## **Planning & Environment (NSW) (MP 07 0112 MOD 8)**

### **Warrell Creek to Urunga Upgrade (Modification 8)**

The purpose of this submission is to provide our comments on the Modification Request.

| <p>ROADS AND MARITIME SERVICES</p> <p>NAMBUCCA SHIRE COUNCIL</p> <p>HW10 PACIFIC HIGHWAY UPGRADE</p> <p>WARRELL CREEK TO NAMBUCCA HEADS</p> <p>OCR SOUTH &amp; NORTH FACING RAMPS - SIGNAGE AND ROAD FURNITURE</p> <p>PLAN - SHEET 5</p> | <p>WC2NH-DD04-LR01-DRG-4305</p> <p>DS2014/005111</p> |

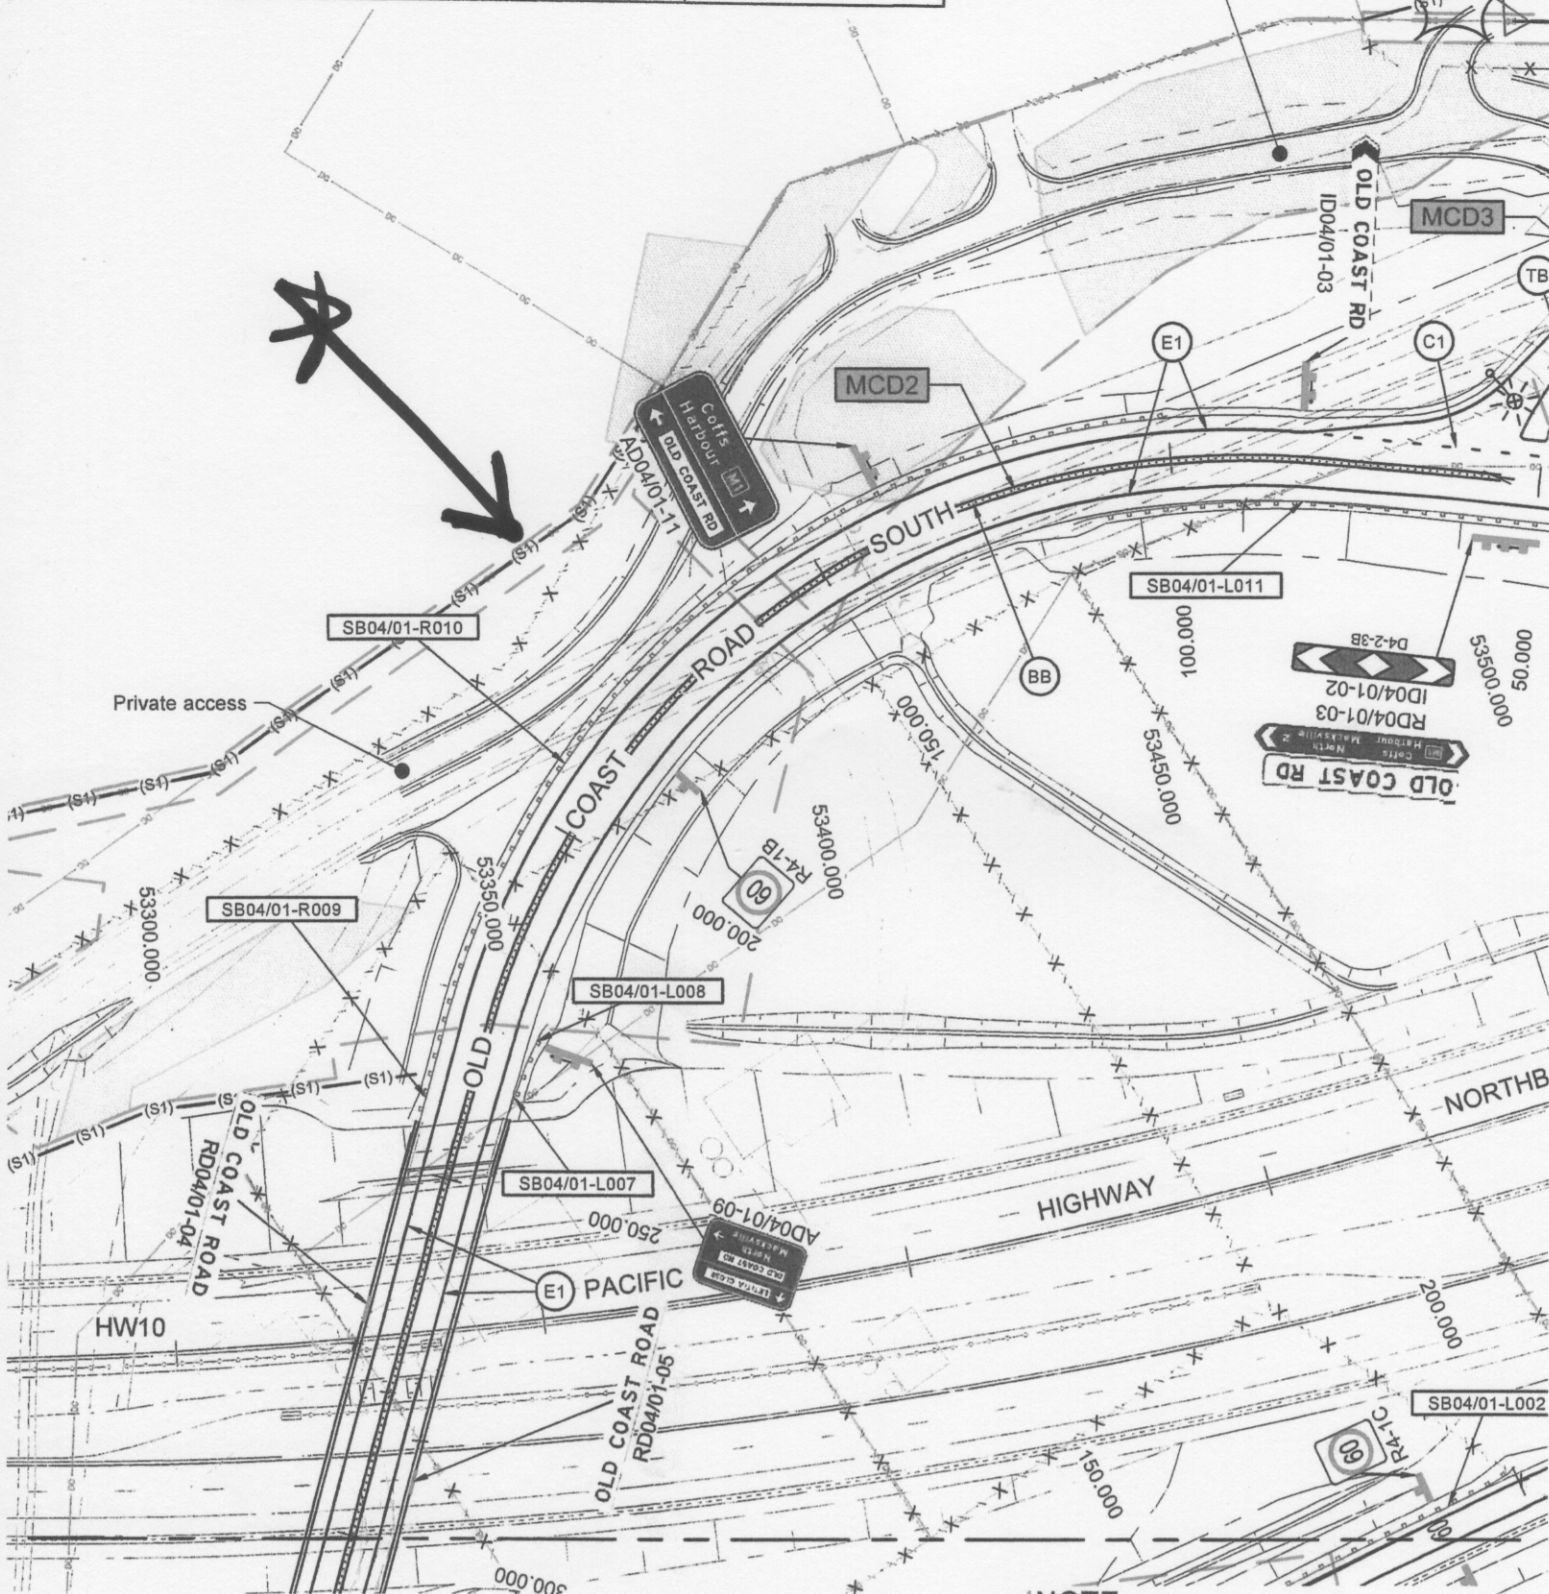
When the ramp design is being finalised we request that a level area be identified to facilitate rubbish collection. We currently have an area by the side of the Old Coast road which allows us to safely locate 8 bins for collection. The new area will need to provide easy access for the rubbish truck.

In addition to the area required for the 8 bins, we will also need an area for 4 mailboxes.

We understand that the lane from Old Coast Road to our driveway will be surfaced as part of the ramp implementation.

We ask that the area being surfaced is identified with consideration for the few remaining mature trees that we have. The lane may need to be moved (very slightly) East to achieve this. There are a few trees close to our homes and we would like to keep them. There should be sufficient area available to enable this.

As the new access will be in a different direction we request that further discussion take place about our driveway design in order to achieve the best outcome, we have some concerns about the tentative driveway design currently shown on the plan.
